BENGALLA MINE

DEVELOPMENT CONSENT MODIFICATION Response to Submissions

October 2015

BENGALLA MINE
Modification Overview - Year 4 Mine Plan
FIGURE 2

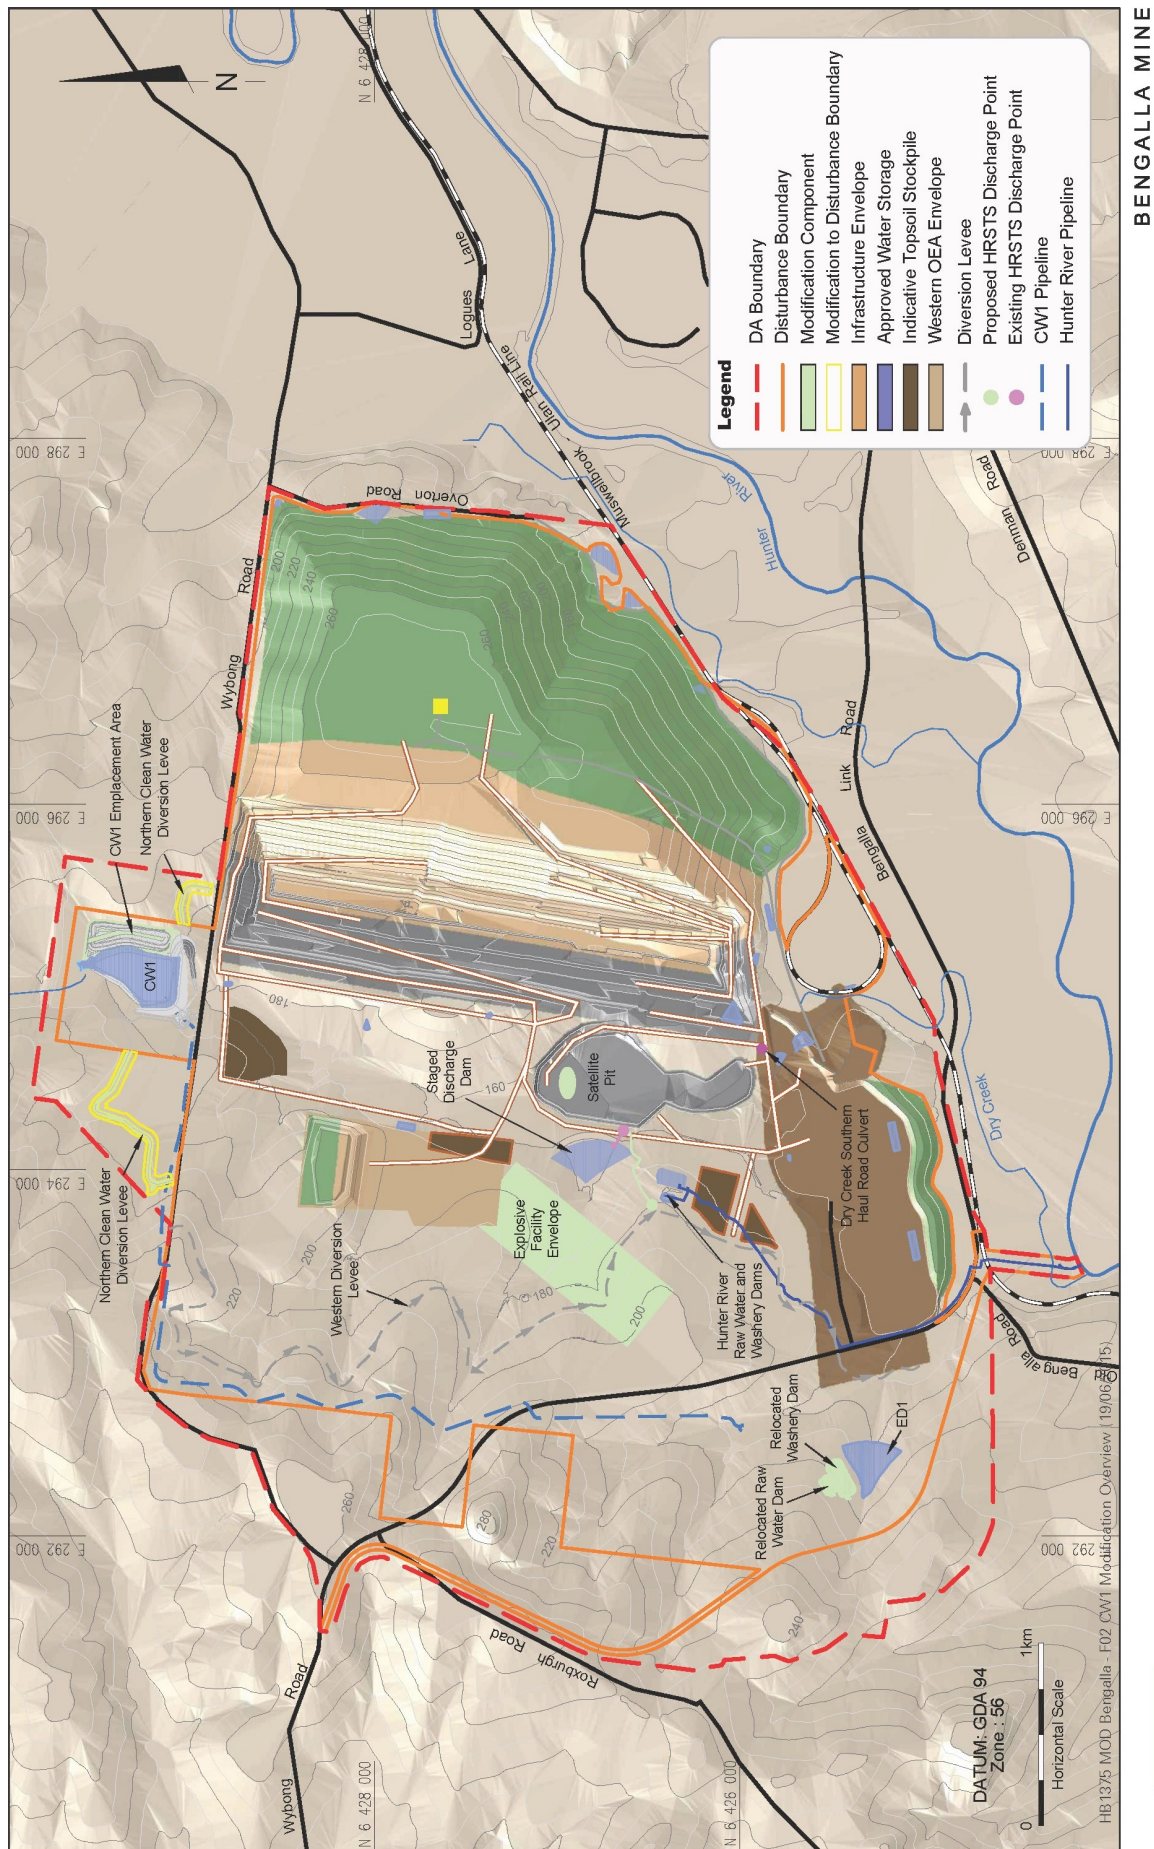
- 1. Provide a new figure showing the Project Boundary and the mining titles within it (request via email dated 15 September 2015).*
- 2. Identify the areas within the catchment for the Satellite Pit that will generate clean or dirty water. A figure or figures showing the catchment and which sections are clean water and which are dirty water would be beneficial (request via email dated 15 September 2015).*

- *Use of the satellite pit as a replacement water storage for the Satellite Pit Diversion Dam may increase the volume of mine affected water generated by the project and decrease the volume of clean water discharged to the Hunter River. The Department notes the proponent's assessment that this part of the modification is necessary to avoid the discharge of sediment and mine affected water into the Hunter River: however, the rationale for this statement is unclear in the absence of changes to coal extraction volumes and rates. The Department suggests that further clarification is sought in relation to any changes mine affected water generation and handling, together with identification of any changes to the volume of clean water captured and discharged from the site, to assist assessment of the likelihood and significance of impacts to water resources.*

Figure 2 presents the ‘mine water management catchment area’ associated with the Modification Year 4 Mine Plan. This mine water management catchment area presents the proposed changes to the water management system as sought in this Modification. Surface water runoff captured in the mine water management catchment area has been included in the revised Site Water Balance.

The Modification Overview Year 4 Mine Plan (see **Figure 2**) details a number of mining activities that will generate sediment laden water (dirty water) that BMC is obligated to control as identified by the 'mine water management catchment area'. The control of that sediment laden water (dirty water) will occur within the BMC mine water management system. The water contained within the BMC mine water management system cannot be mixed with clean water. It is not possible for the mining activities described in the Modification SEE to occur with the currently approved Satellite Pit Diversion Dam remaining a clean water dam. Therefore the Satellite Pit Diversion Dam is not required and the sediment laden water (dirty water) will be controlled (caught) by the Satellite Pit and then that water integrated into the BMC mine water management system.
